# memorandum

date September 17, 2019  
to Nicole Gaudette, Senior Planner  
from Christina Hersum and Scott Olmsted, Biologists, ESA  
subject CAO19-014 – Environmental Review for Headrick Property Redevelopment

BUFFER RESTORATION PLANTING PLAN

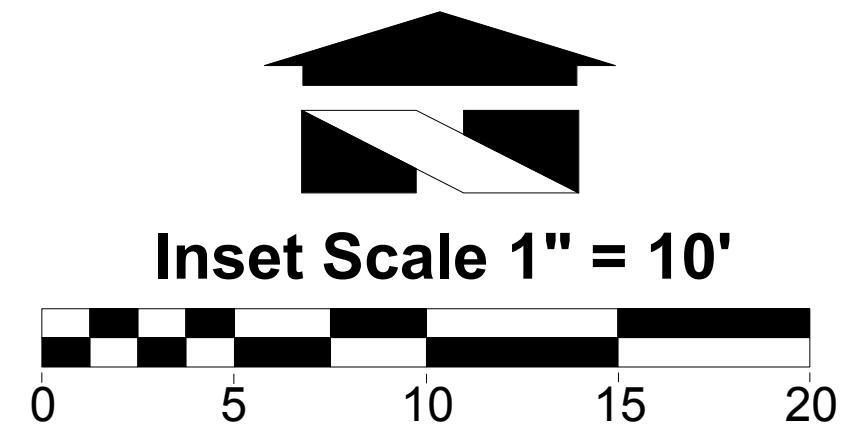
According to Performance Standard 1b1 of the Buffer Restoration Plan, installed and native volunteer species shall achieve 50 percent aerial cover by Year 5. ESA finds that 50 percent aerial cover is a low requirement for Year 5 aerial cover performance standards, and recommends an increase to 70 percent. To help achieve 70 percent aerial cover by Year 5, ESA recommends the following based on the proposed plantings and quantities: increase the density of proposed plantings (e.g. use 4-foot spacing for shrubs and 2-foot spacing for groundcovers); and/or install additional salmonberry plantings rather than strawberry groundcover plantings.

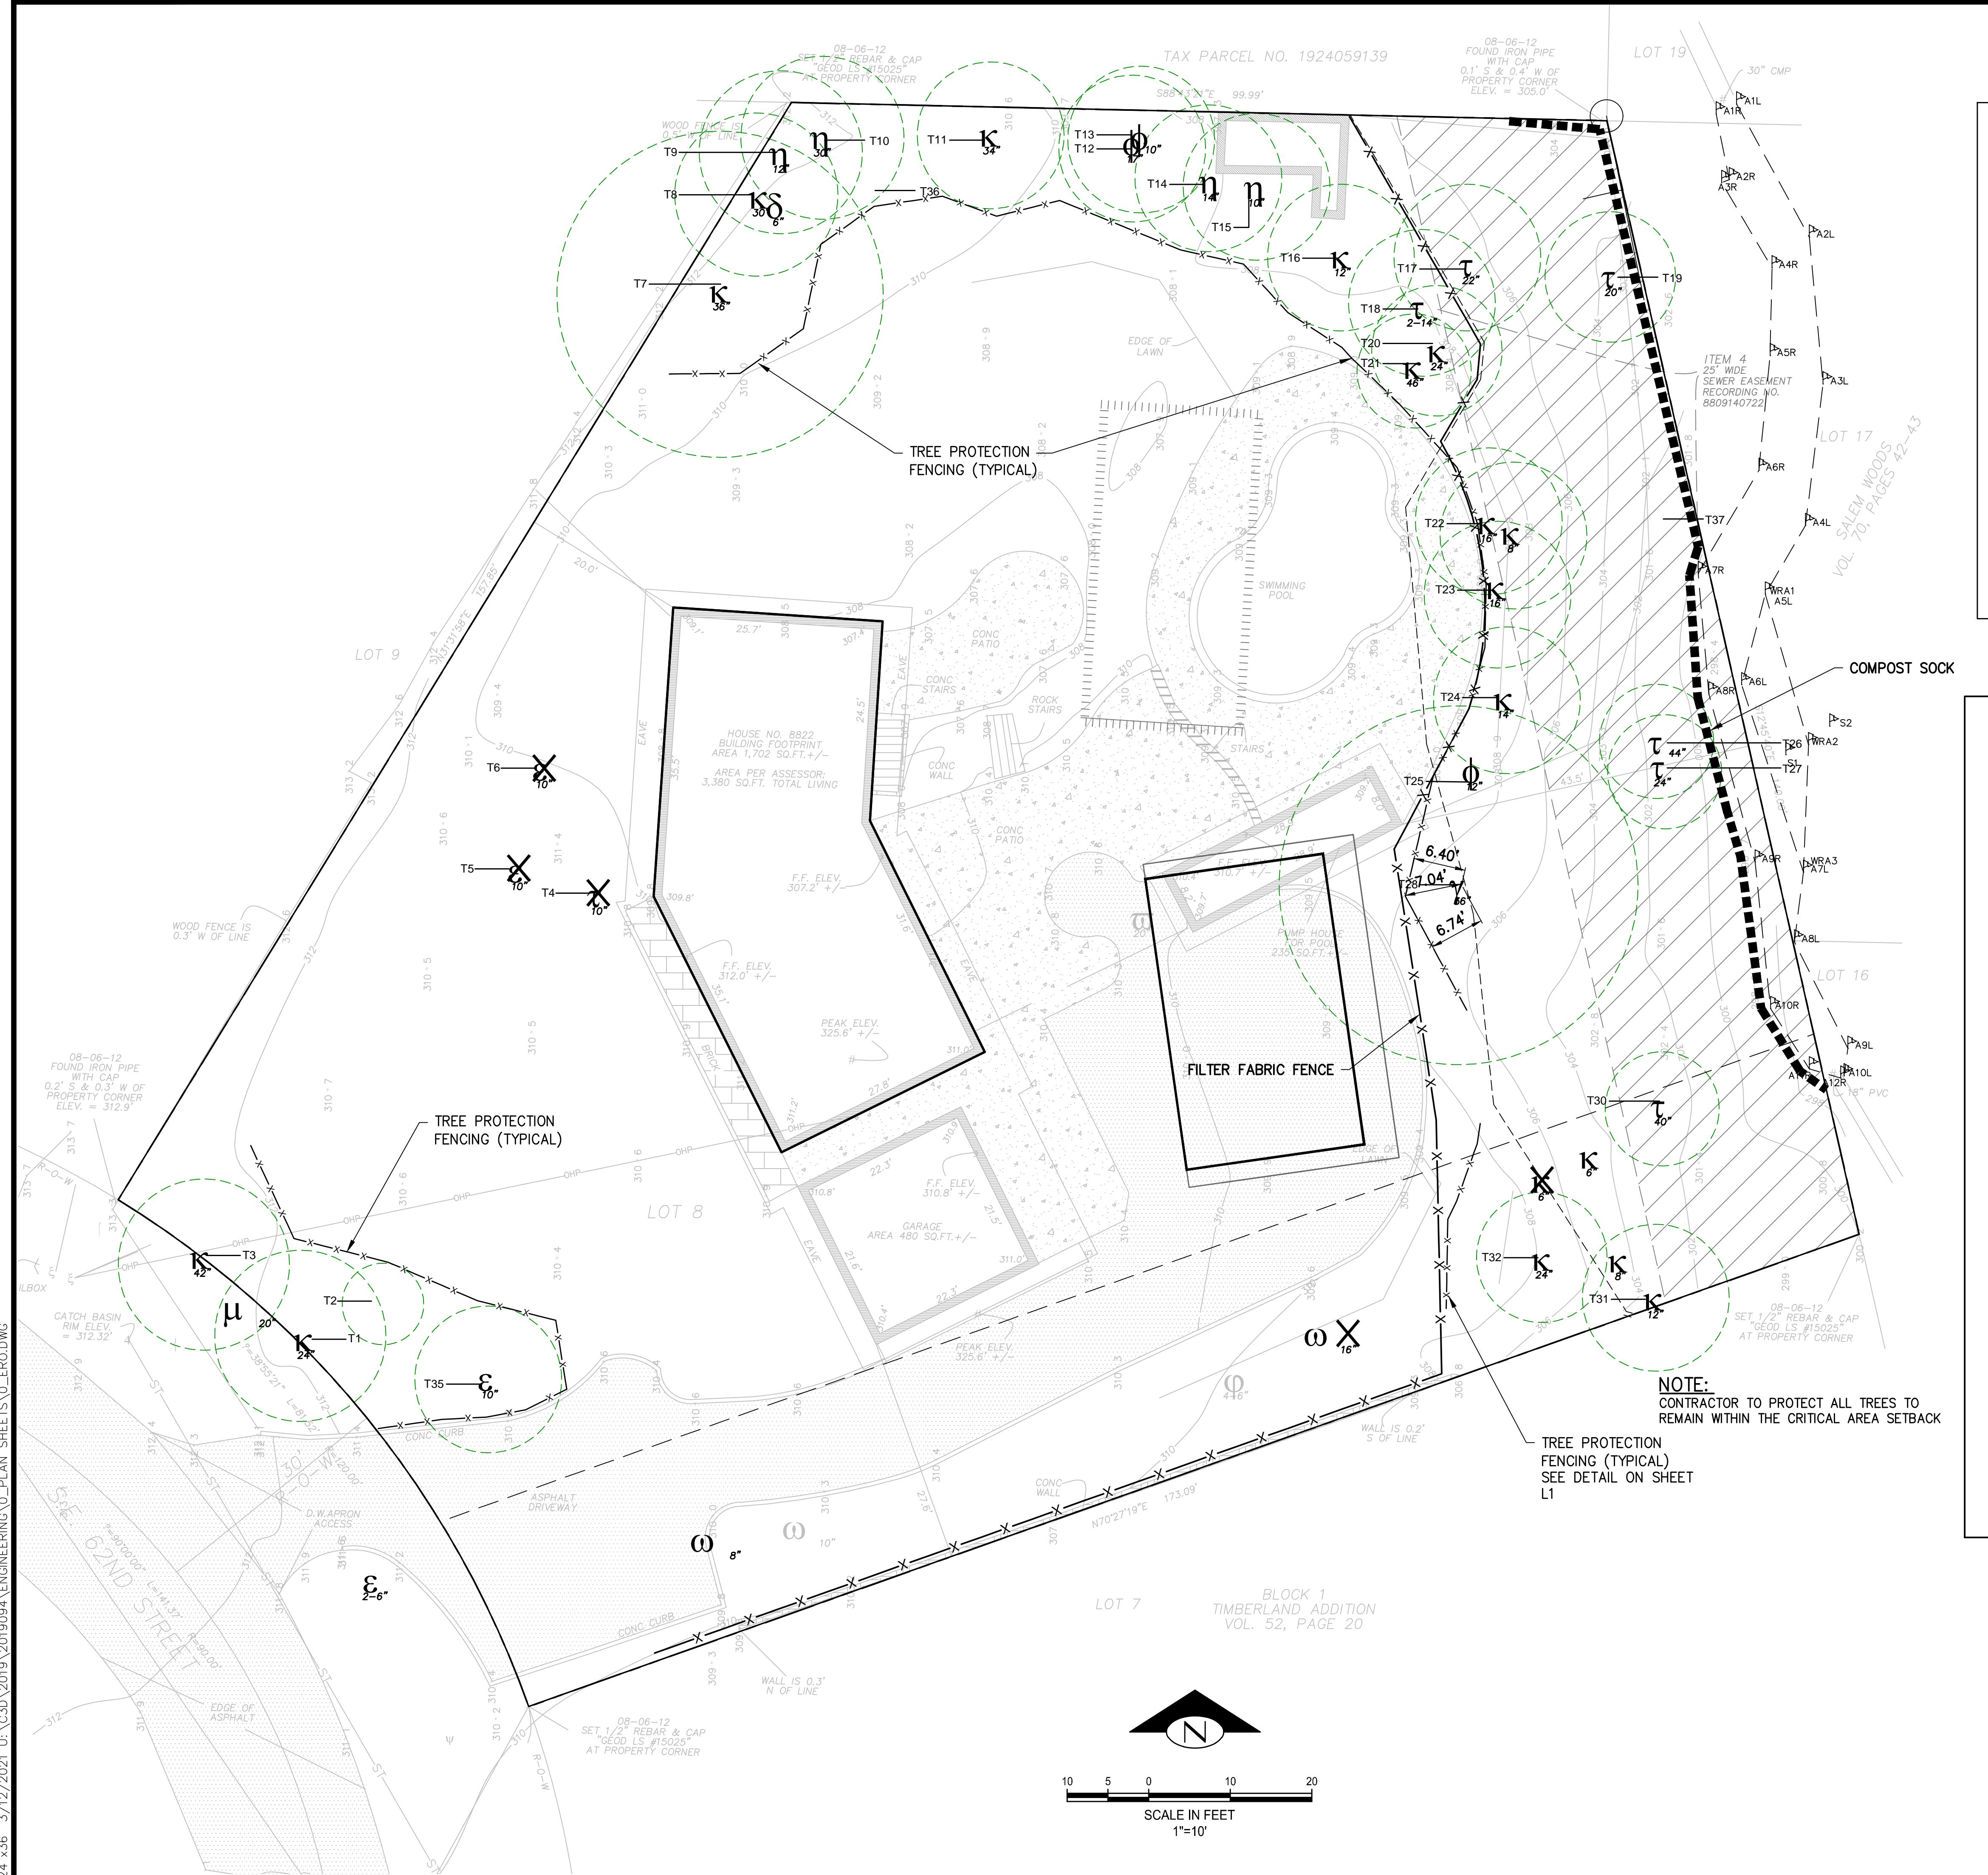
According to the Project Plans, the applicant also proposes to construct stormwater drainage infrastructure through the southern portion of the 35-foot buffer, connecting to the culvert outlet of Stream A. The CAS does not include the proposed stormwater infrastructure presented in the Project Plans, nor does it address permanent and temporary impacts to the buffer or Stream A resulting from proposed stormwater infrastructure construction or mitigation for these impacts. Based on these findings, we find that the CAS and Buffer Restoration Plan are not fully in compliance with the code requirements for critical area study content per MICC 19.07.050.

According to the Project Plans, most of the proposed development will occur outside of the standard buffers for Stream A and Wetland A; however, it appears that some stormwater drainage infrastructure will be constructed through the southern portion of the buffer, connecting to the culvert outlet of Stream A. While the construction of stormwater infrastructure within a critical area is not explicitly stated as an allowed alteration per MICC 19.07.030, we believe impacts from the proposed stormwater infrastructure will be generally small and temporary within the buffer, but any direct impacts to Stream A should be avoided.

- Provide more information regarding the stream gradient and potential for fish use to determine the stream type per the interim rule, WAC 222-016-031.
- Revise the CAS and Buffer Restoration Plan to include impacts and mitigation for proposed stormwater infrastructure within Stream A and the 35-foot buffer.
- Revise Performance Standard 1b1 of the Buffer Restoration Plan to require 70 percent aerial cover at Year 5, including suggestions for planting species and spacing to achieve that standard.
- Consider revising the Project Plans to avoid direct impacts to Stream A from stormwater infrastructure construction.
